**Washington State
Department of Transportation**

Subject: BL-11-00007, Duane Cameron – 2-Lot BLA.
SR 970, MP 6.10 Left Vicinity

We have reviewed the proposed boundary line adjustment, and have the following comments.

RECORD OF SURVEY
 A PORTION OF THE WEST 1/2 OF
 SECTION 25, TOWNSHIP 20 NORTH, RANGE 16 EAST, W.M.,
 KITTITAS COUNTY, WASHINGTON

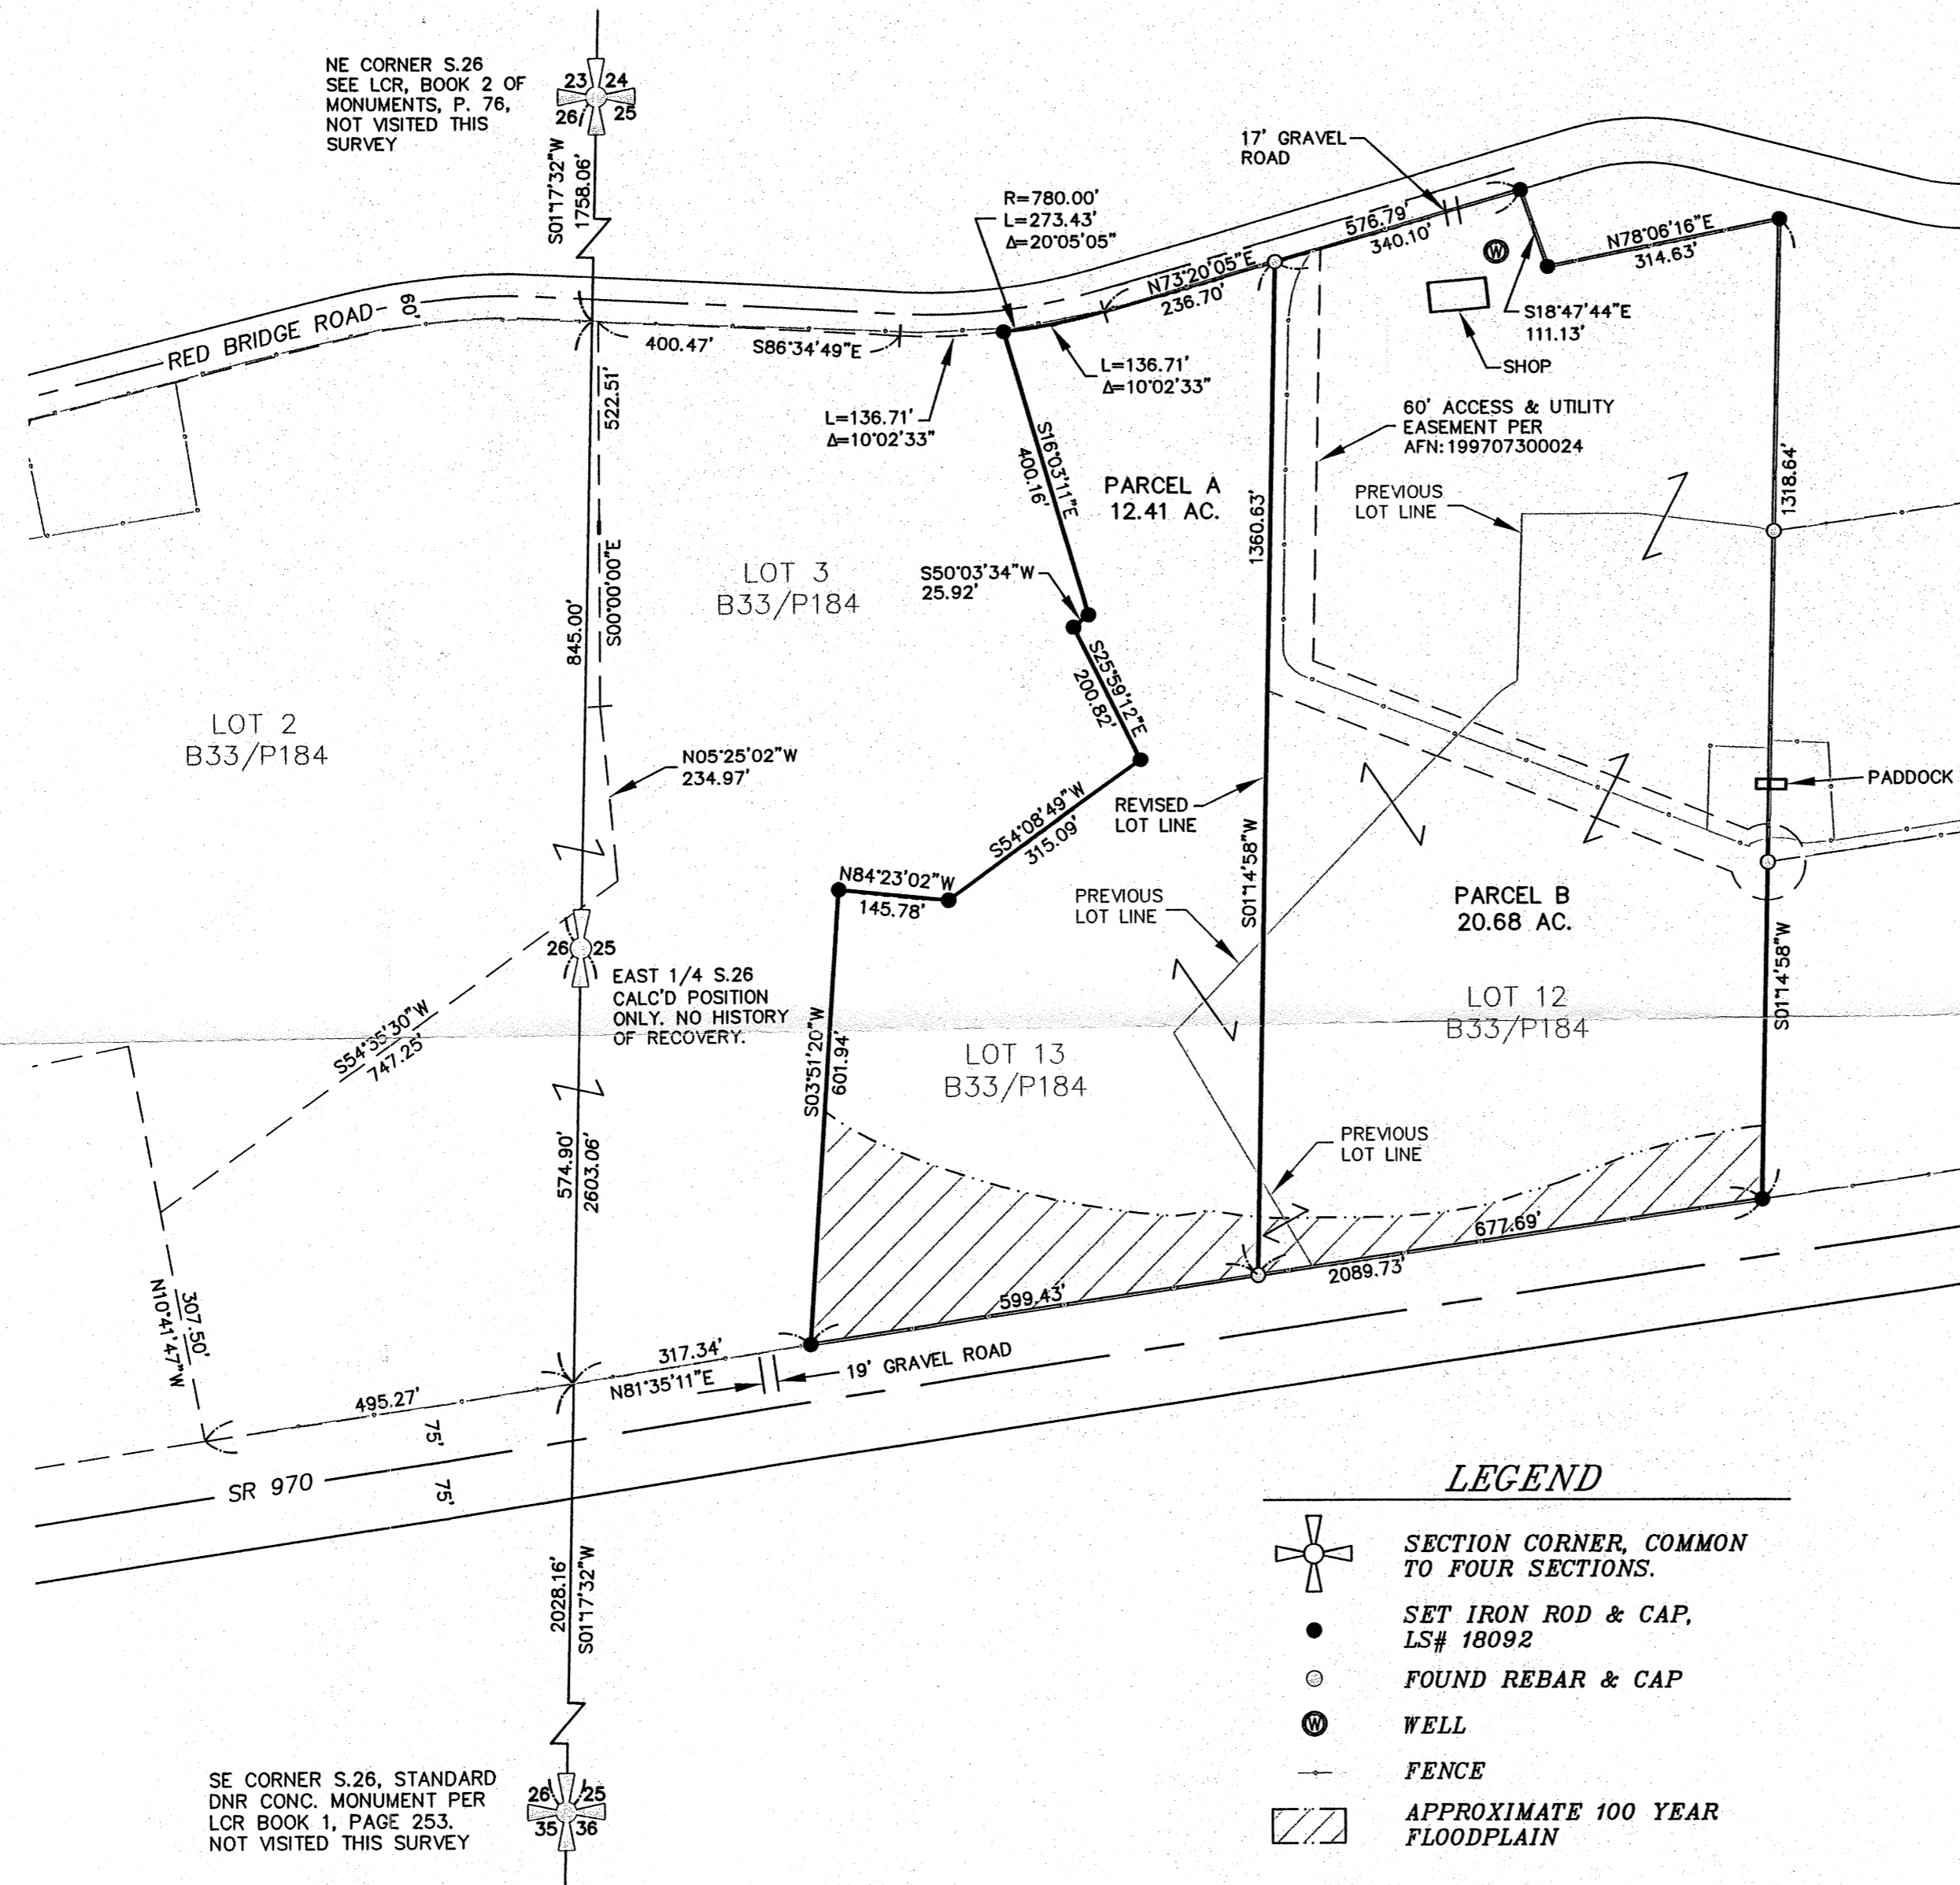
1. The BLA site is adjacent to State Highway 970. SR 970 is a Class 1 access managed highway in this area with a posted speed limit of 60 miles per hour. The WSDOT has no objections to this BLA. Access for the two (2) lots of this BLA will be via Red Bridge Road. No direct access to SR 970 will be allowed for either of these two lots.
2. Stormwater and surface runoff generated by this project must be retained and treated on site in accordance with regulating agencies' standards, and not be allowed to flow onto WSDOT rights-of-way.
3. Any proposed lighting should be directed down towards the site, and away from SR 970.
